Re: Application 6/2016/1855/VAR

Further to your recent notification concerning the above application and that the appellant has applied to remove condition 2 (obscured glazed dormer windows) we would respond as follows.

North Facing Elevation windows

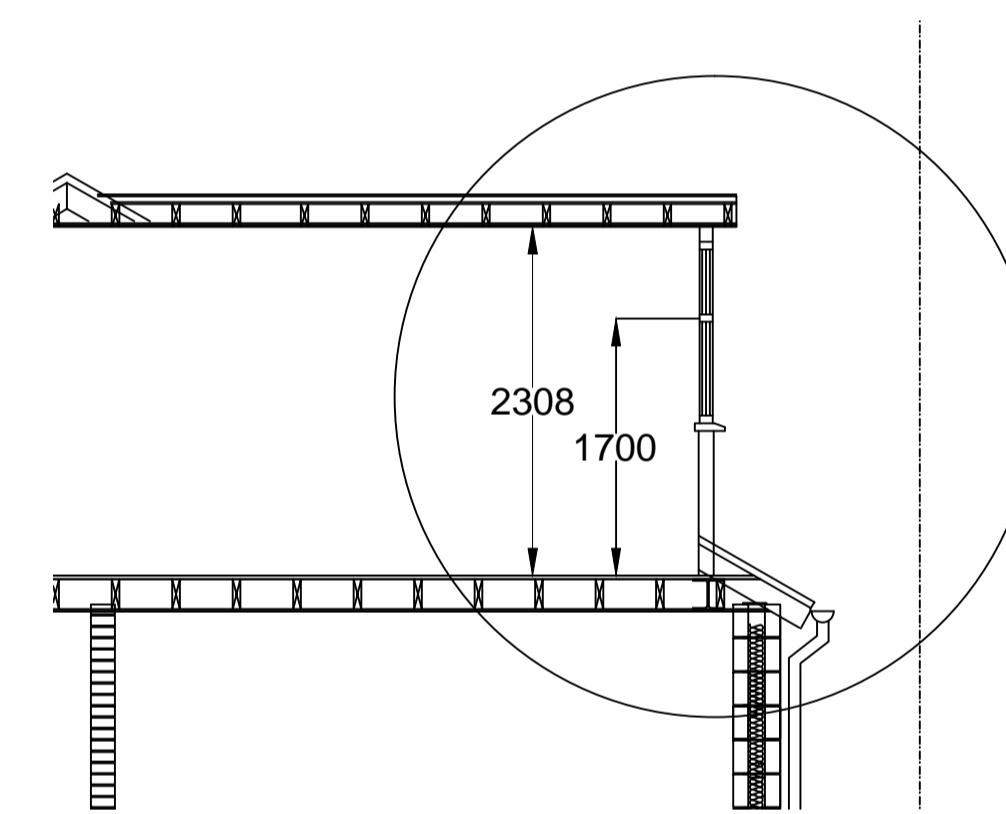
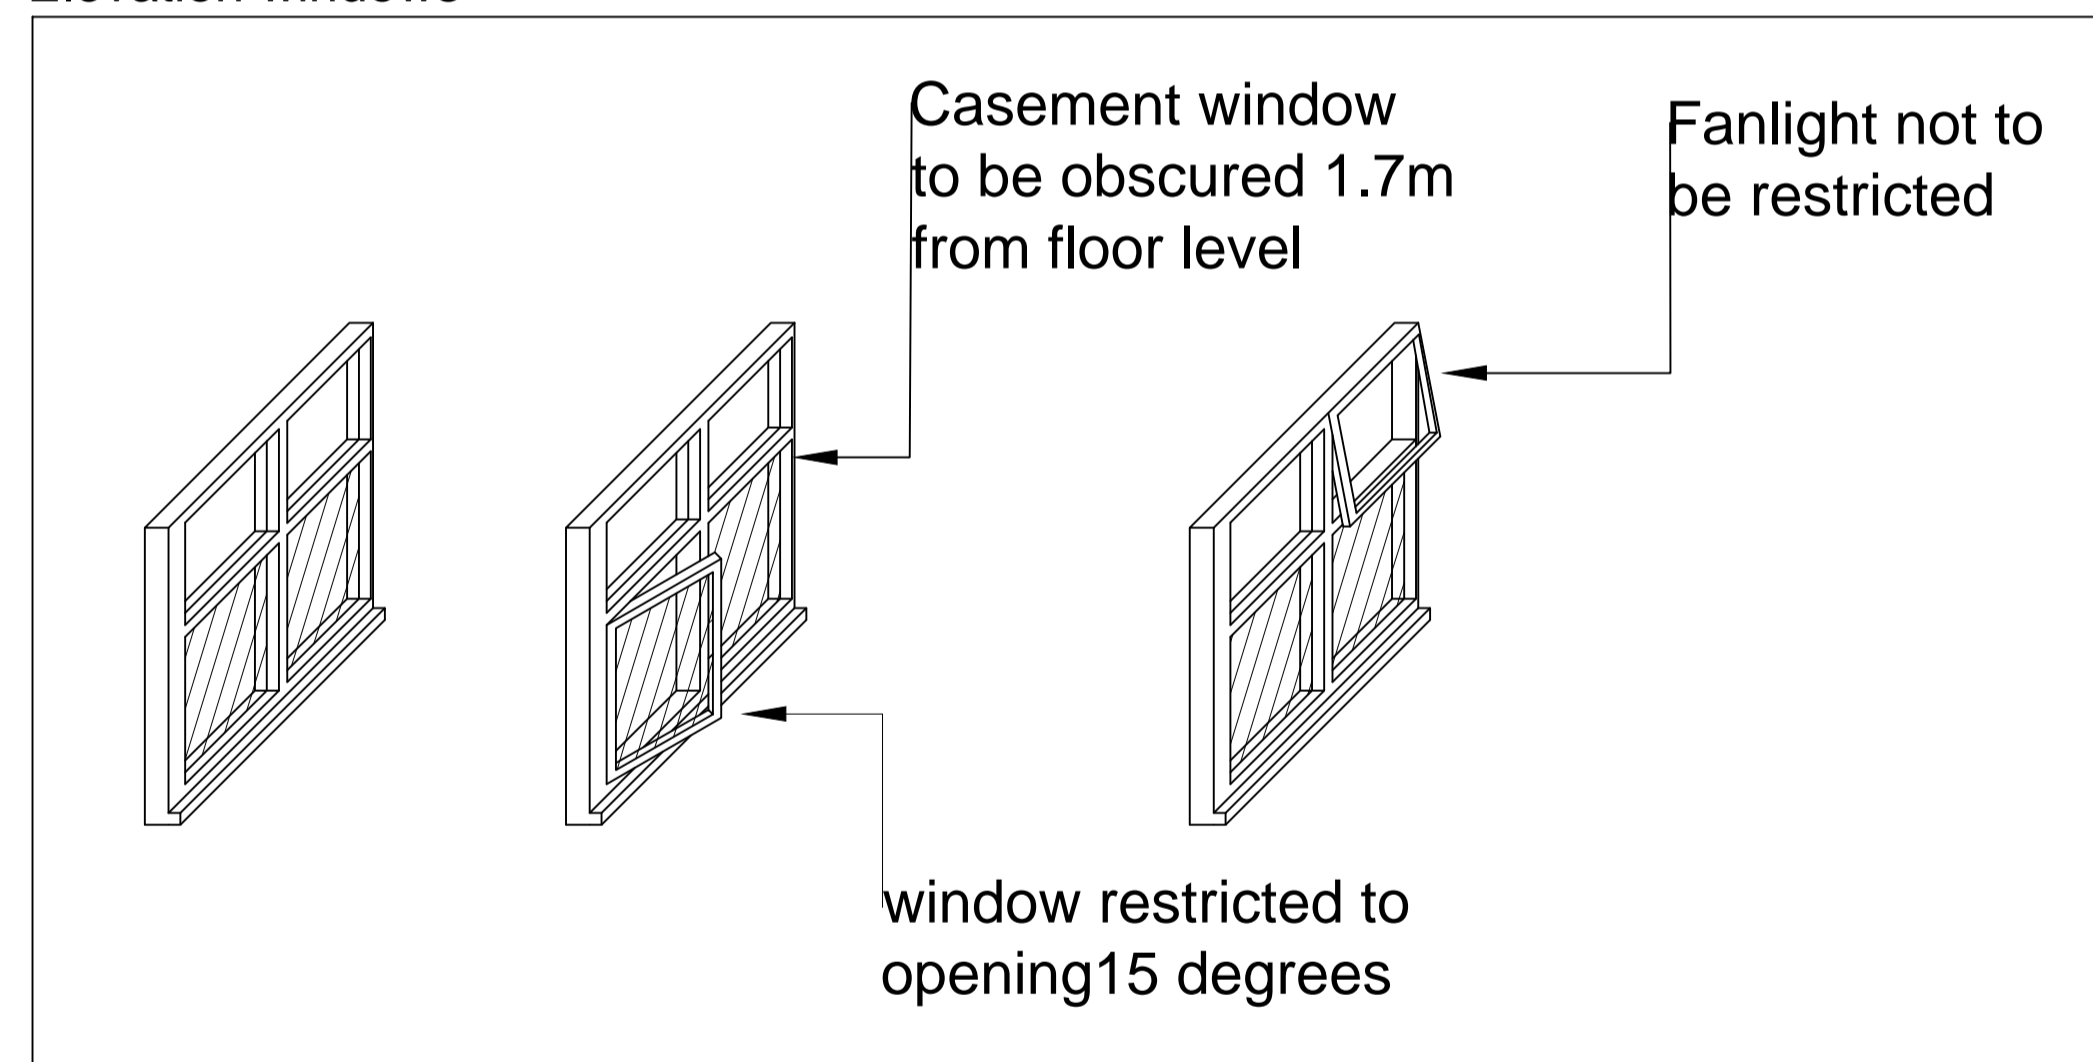
The three dormers that overlook our roof slope do look directly into our habitable rooms.

Our staircase/hall is directly overlooked by two dormers. This staircase is our only access route to our downstairs bathroom from our bedrooms. To be overlooked is again an intrusion to our privacy.

NO. 45 DORMER WINDOWS LOOKING INTO NO. 43 SKYLIGHT BEDROOM

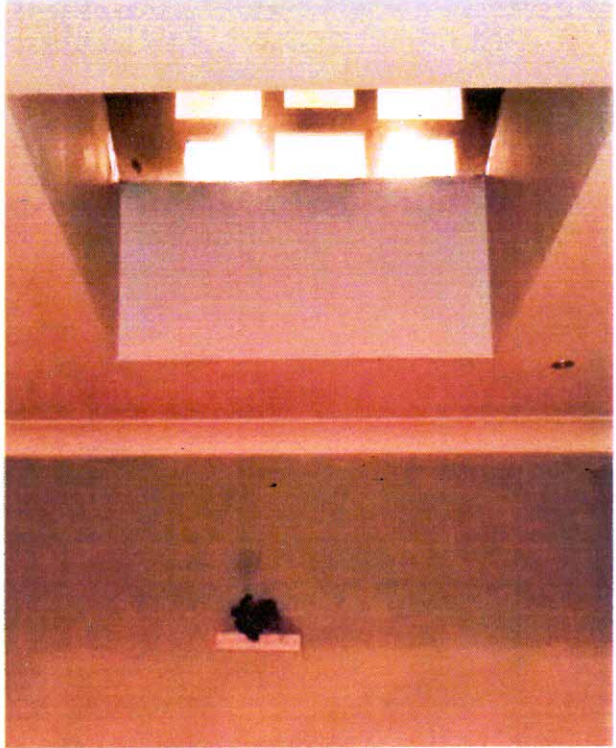
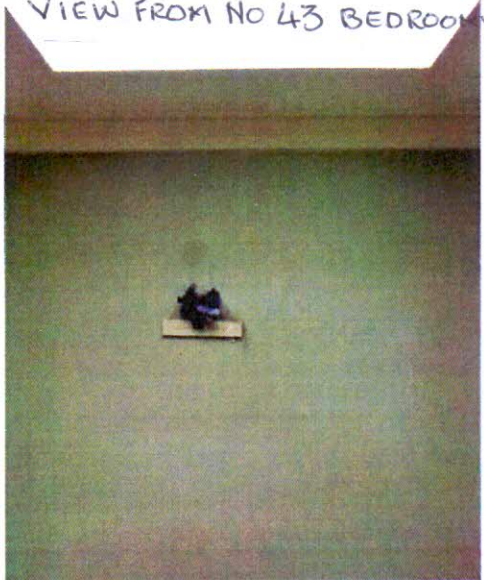
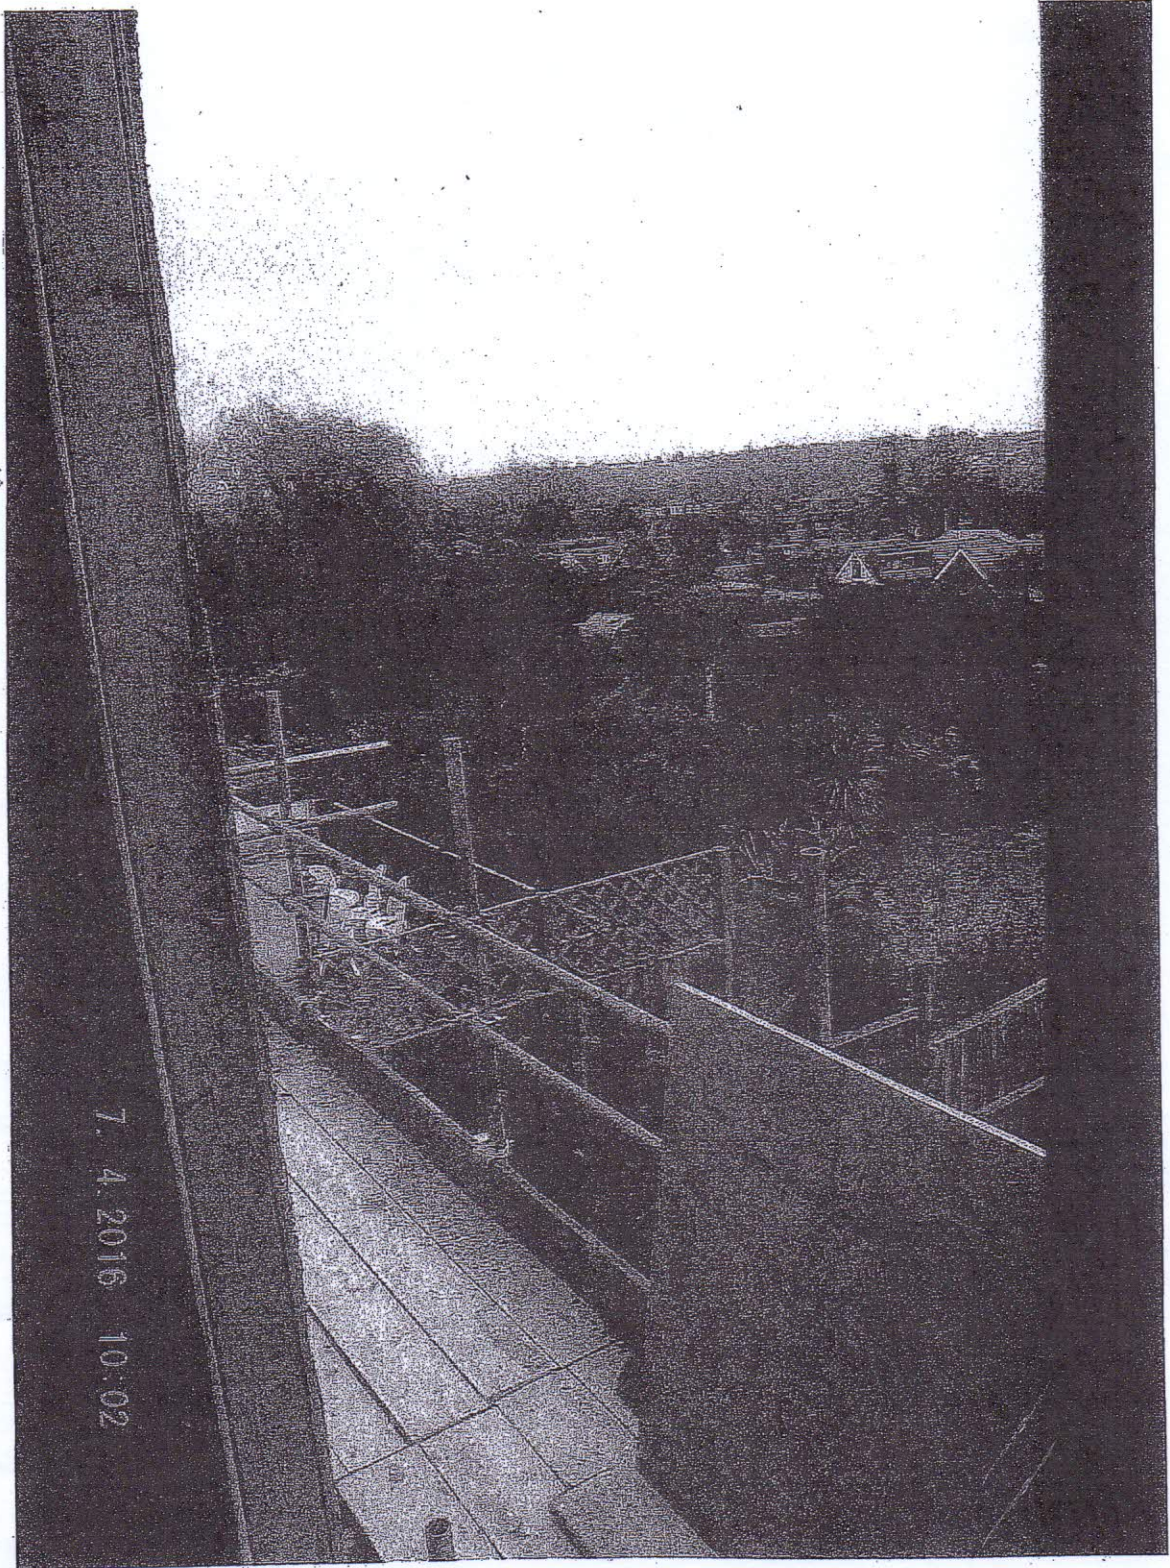
Please see attached photos that illustrate the intrusion into our privacy.

I am somewhat taken a back that the planning consultant says, "there is no overlooking into these rooms". As you can see from the photos this is nonsense and better should be expected from a Planning Consultant.
